ENG-CDR20005-R10-CDs-Vollmer.pdf Markup Summary

**VOLLMER ROAD**  
**STA 10+00.00 TO STA 24+00.00**

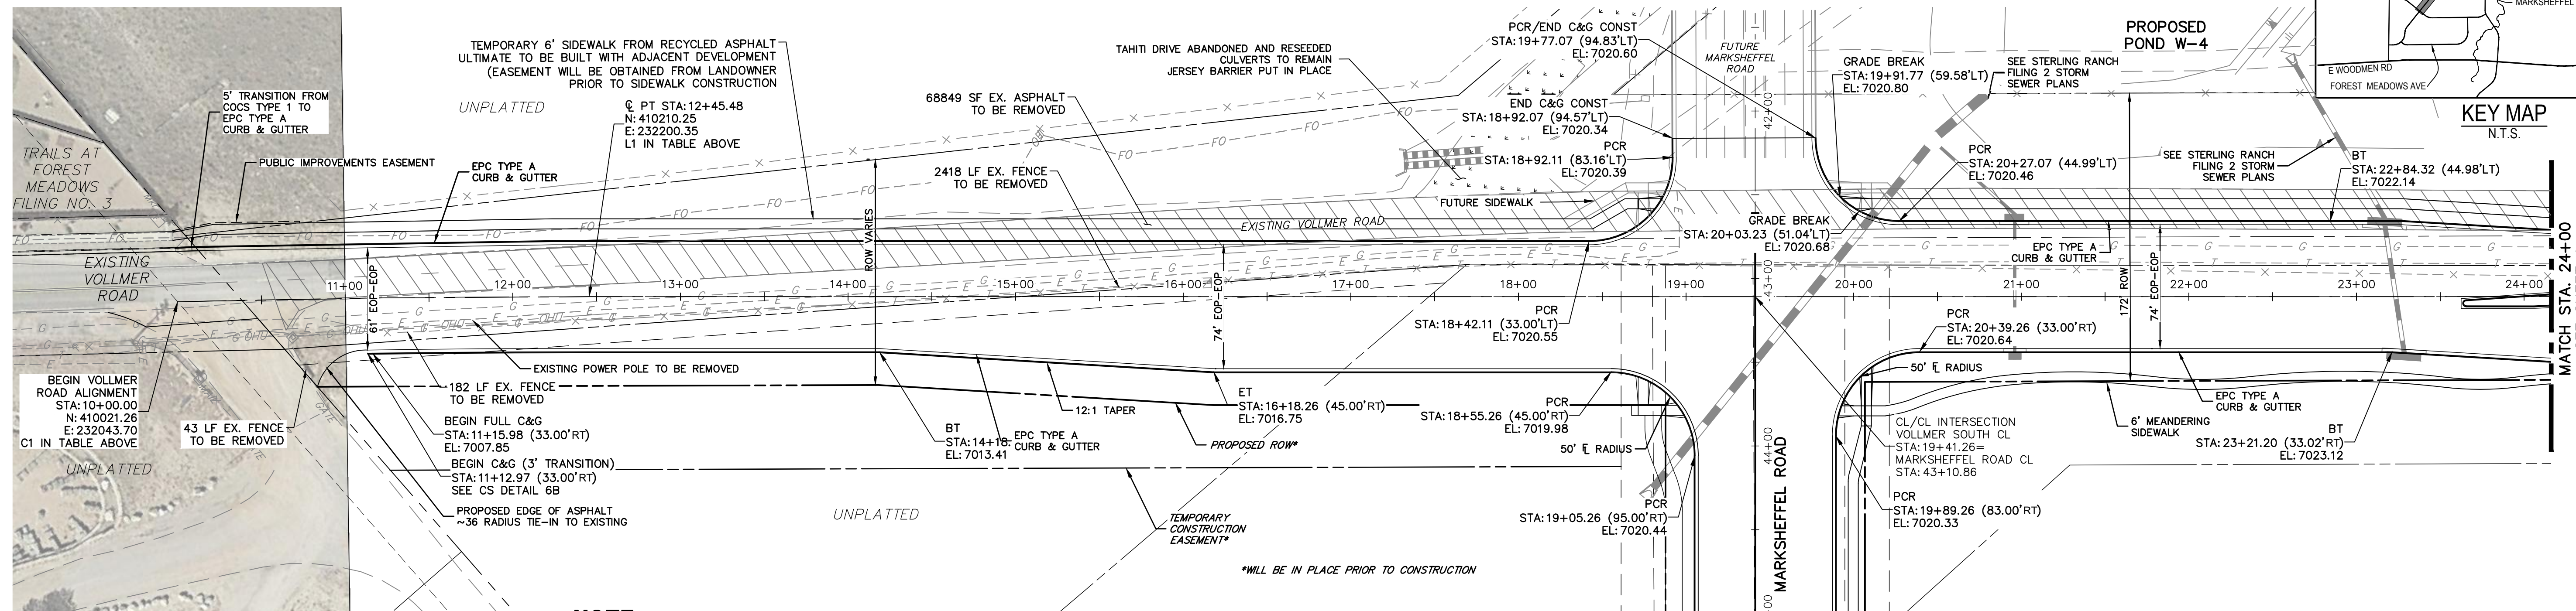
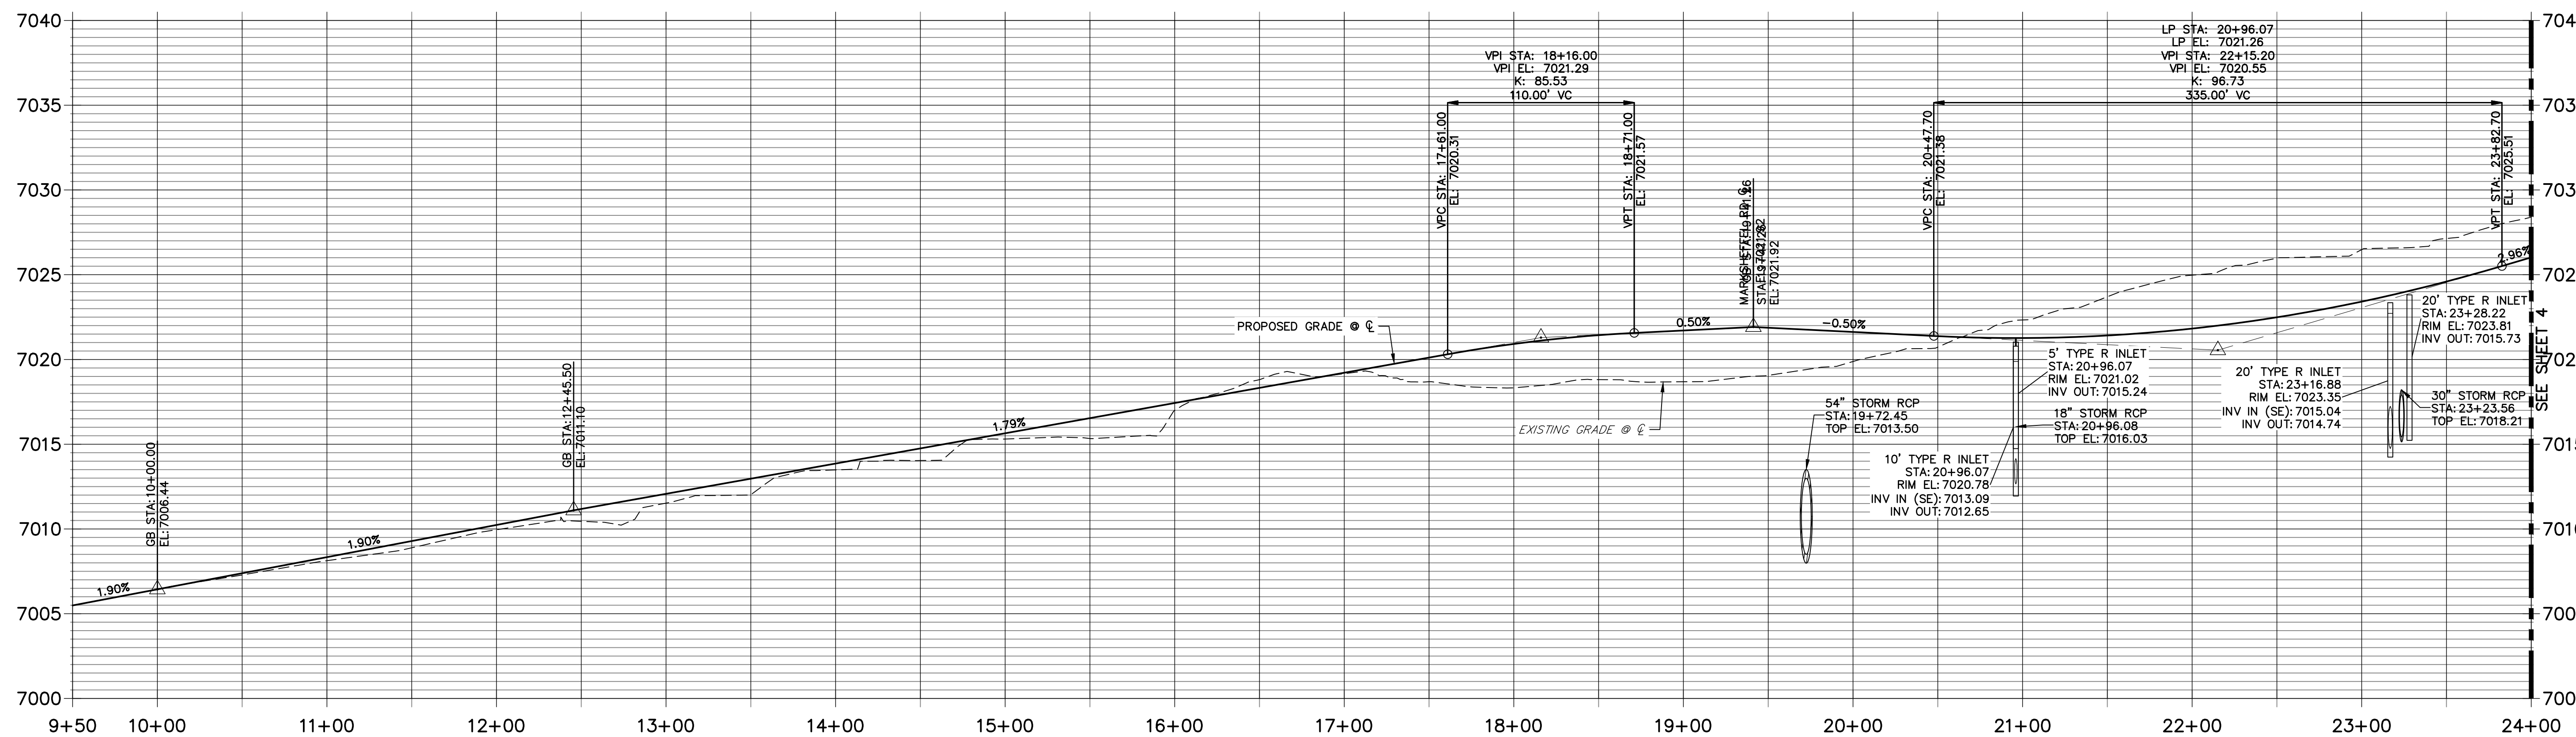
This needs to be tapered in

Is the interim raised median needed?

Why not transition EOP (lose shoulder) here?

provide radius to tie in here (a label to field fit the radius would be fine)

Taper edge of asphalt

**VOLLMER ROAD SOUTHERN TIE-IN TO EXISTING**

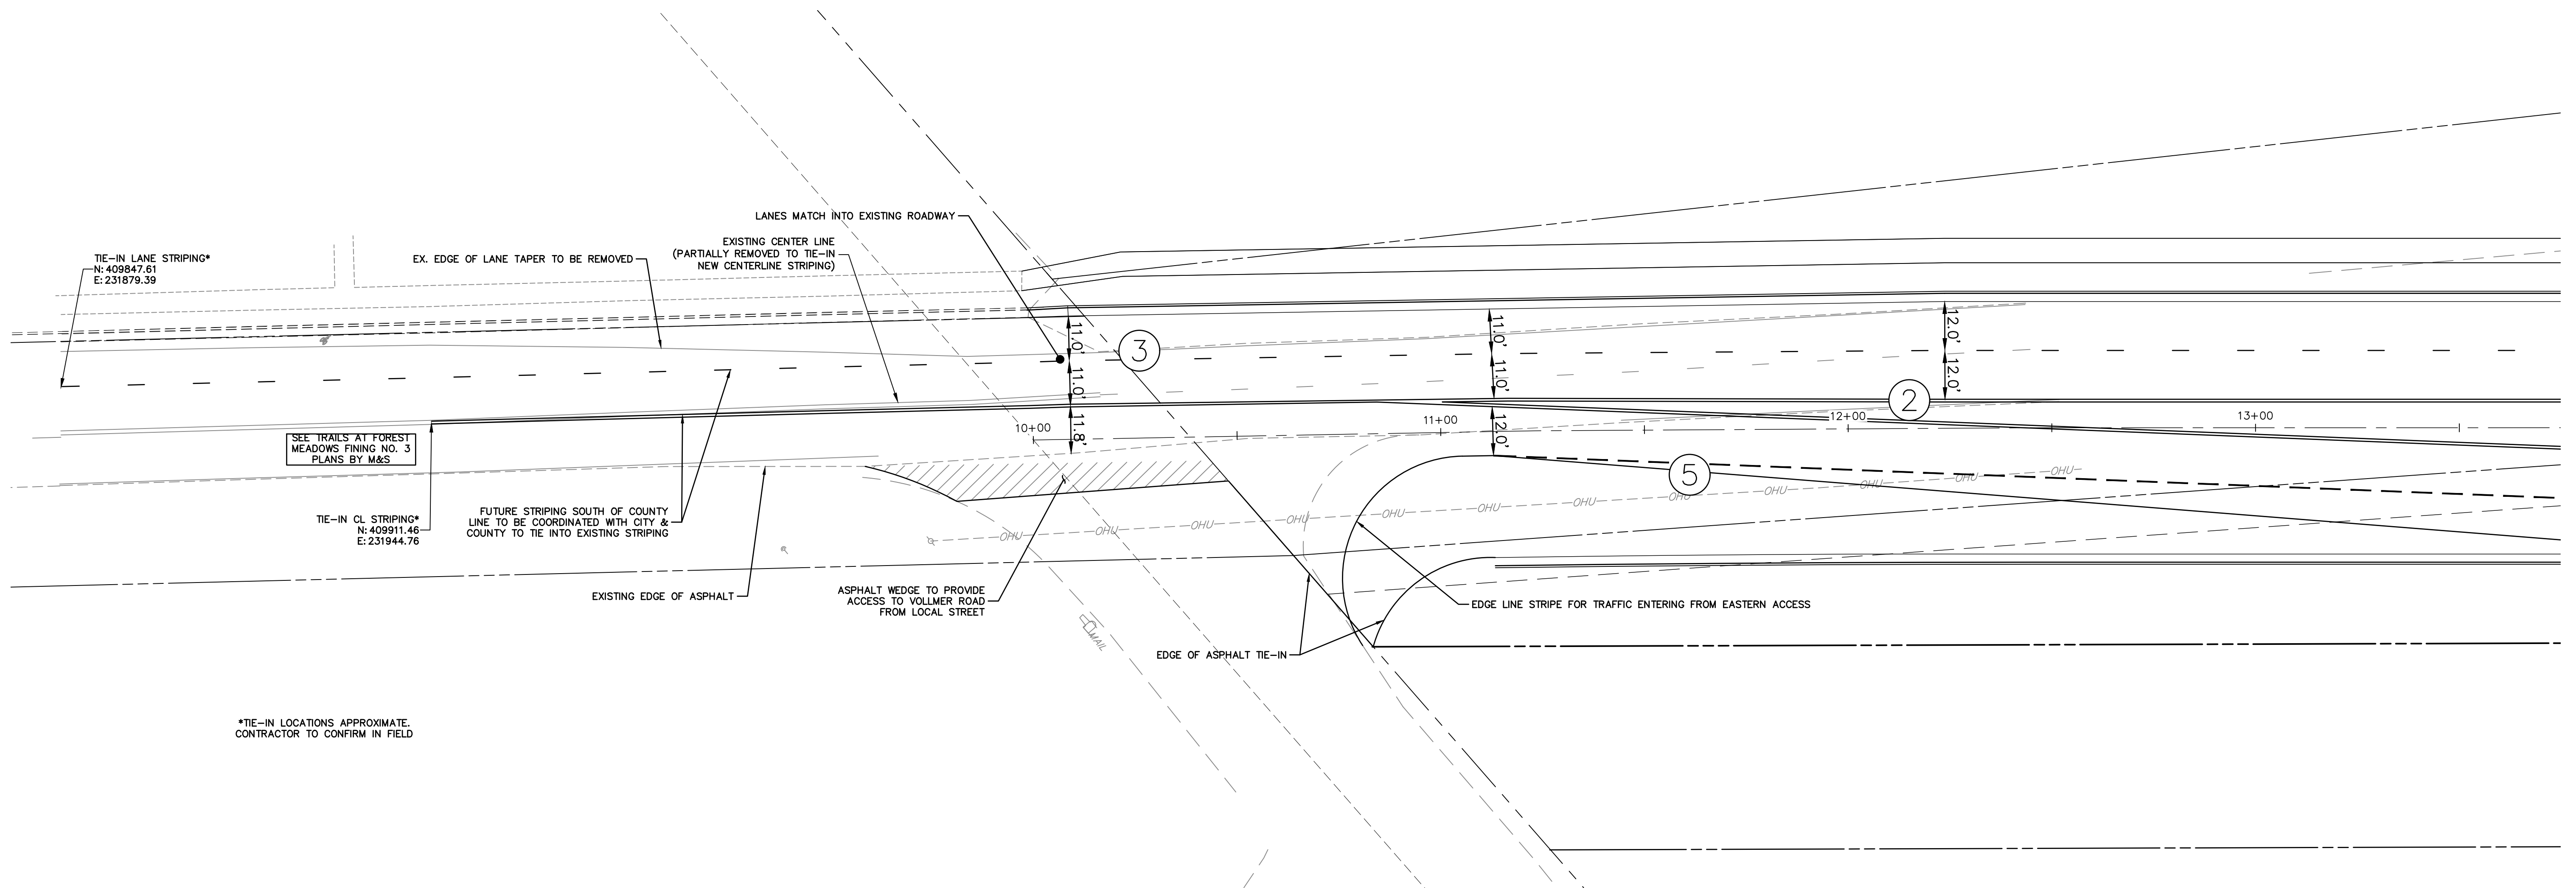
Is this needed in the interim?

**STERLING RANCH - VOLLMER ROAD FILING 2 CROSS SECTIONS**  
 SHEET 9 OF 11  
 JOB NO. 25188.01

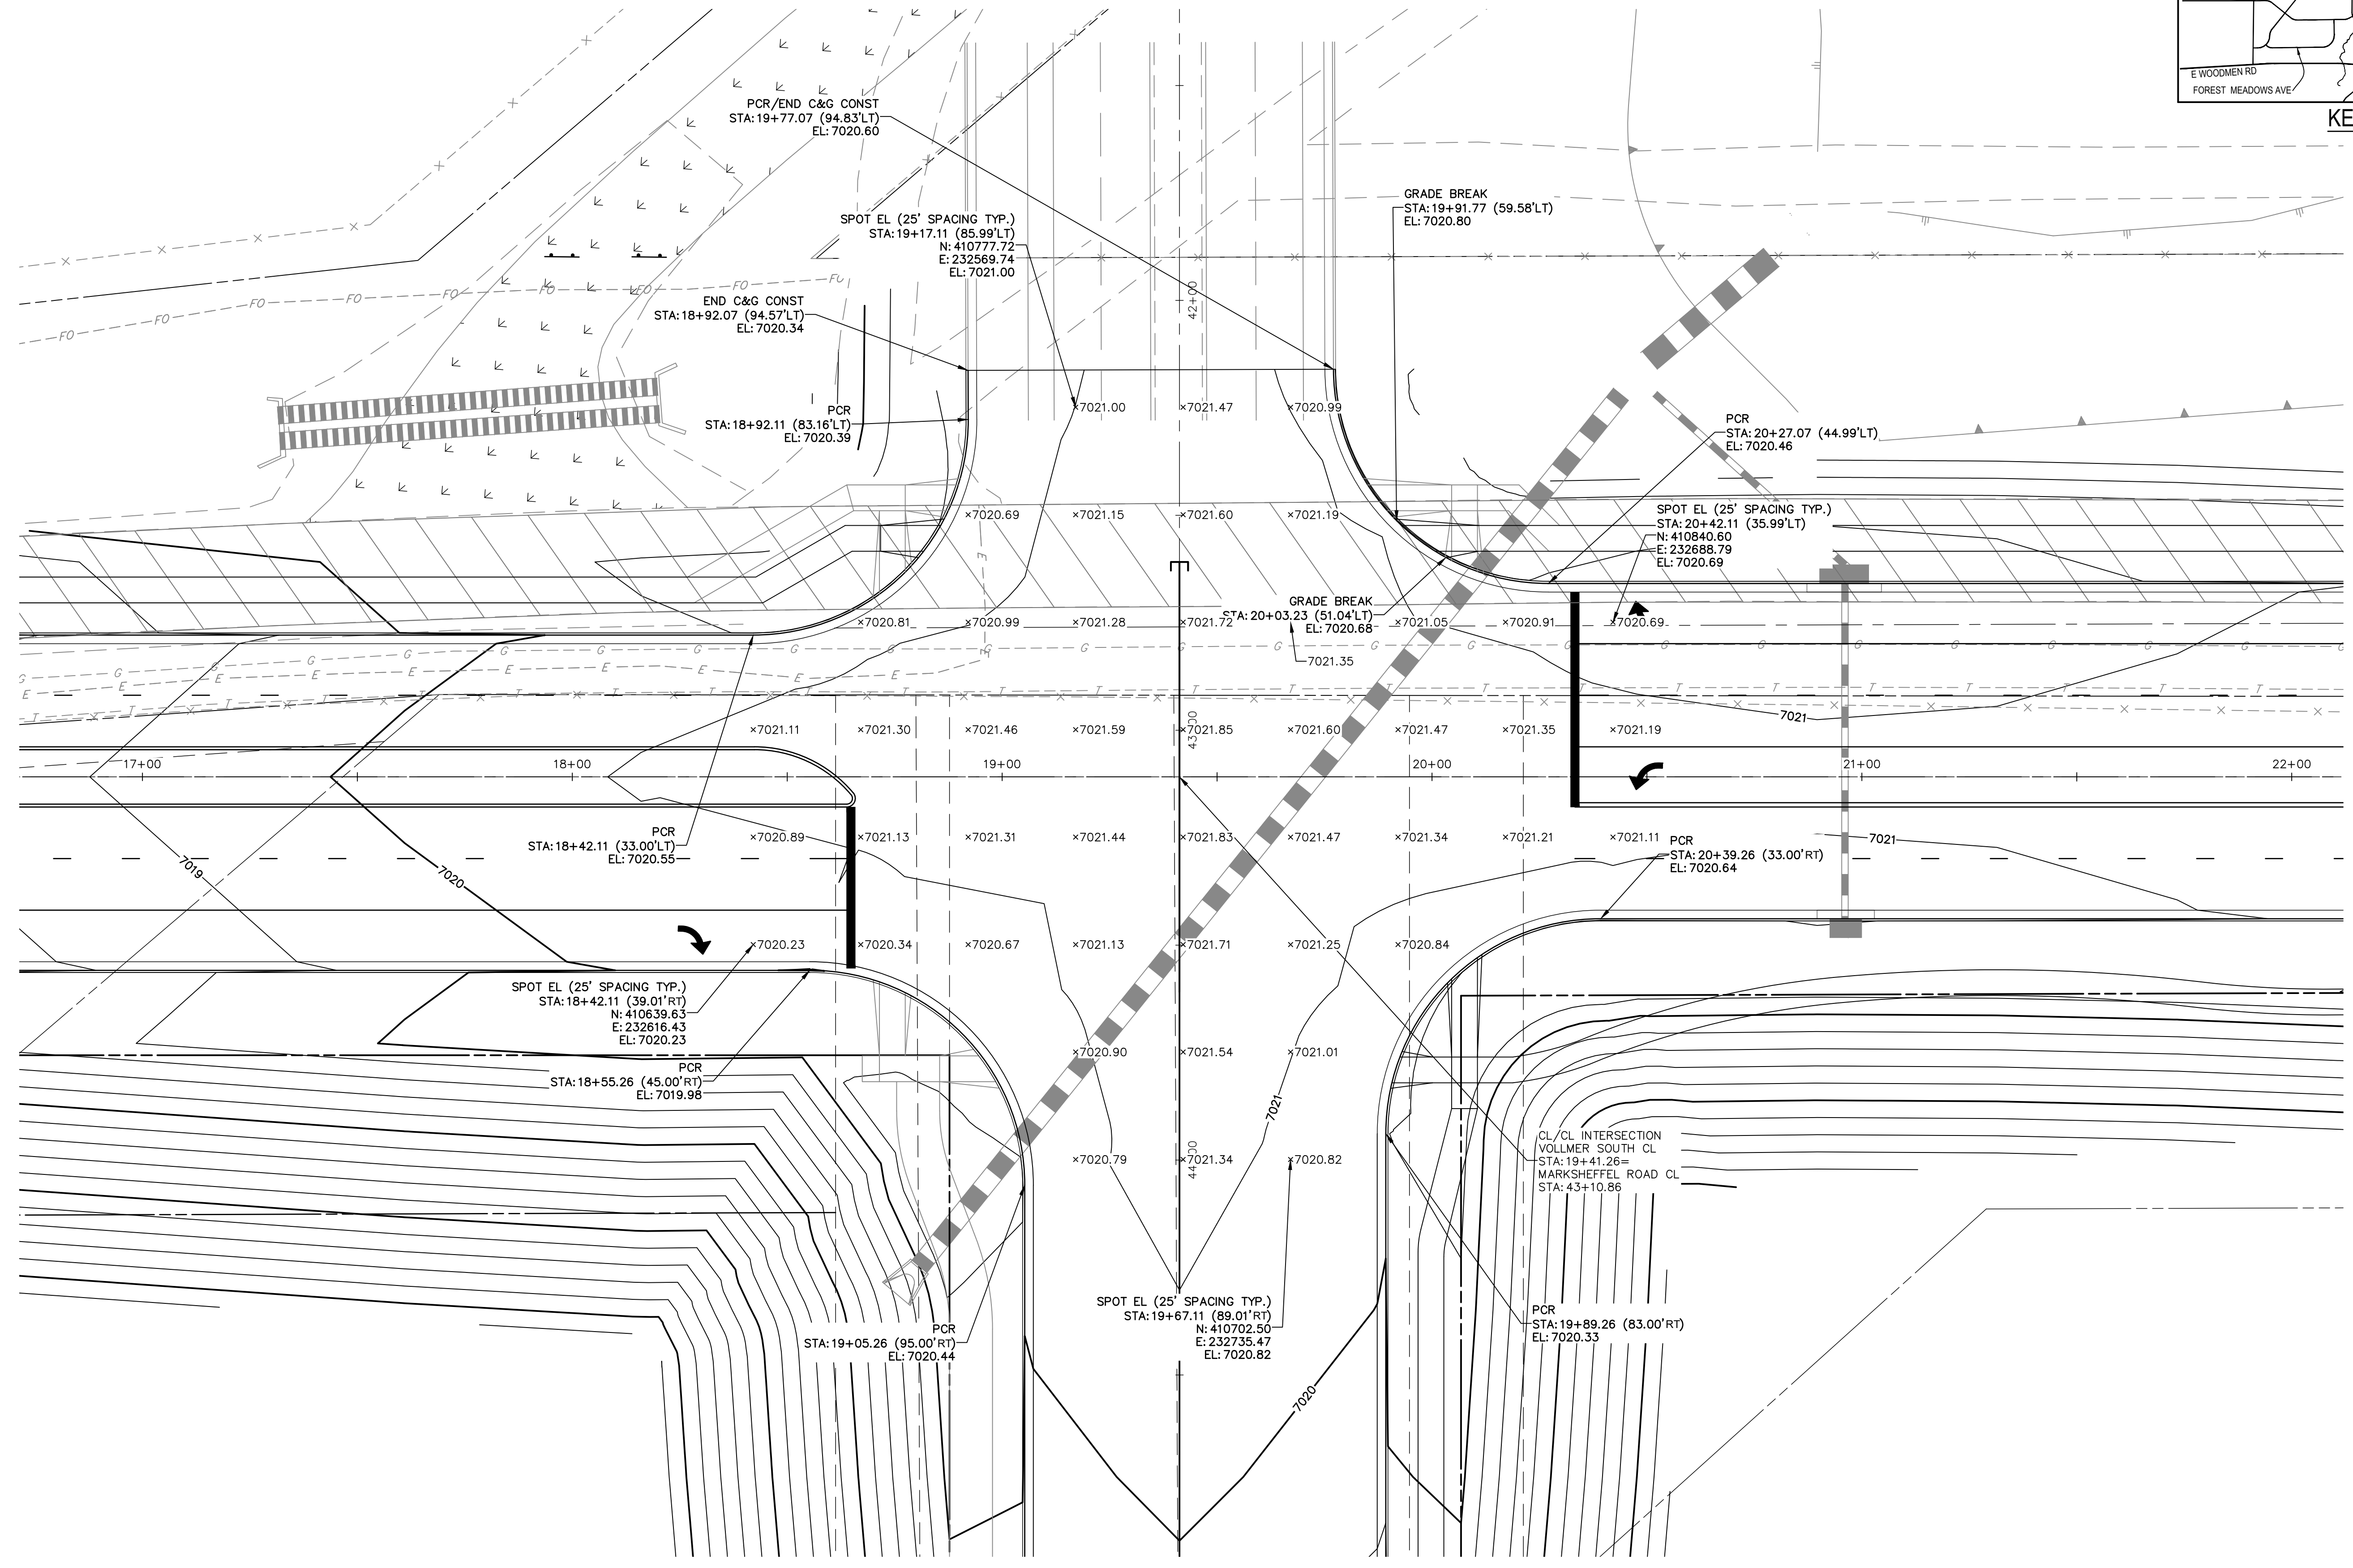
see comments on other sheet

Is this sign needed? (If there is no median to put in) Check MUTCD.

Please dimension to EOP

Not needed if no interim median.
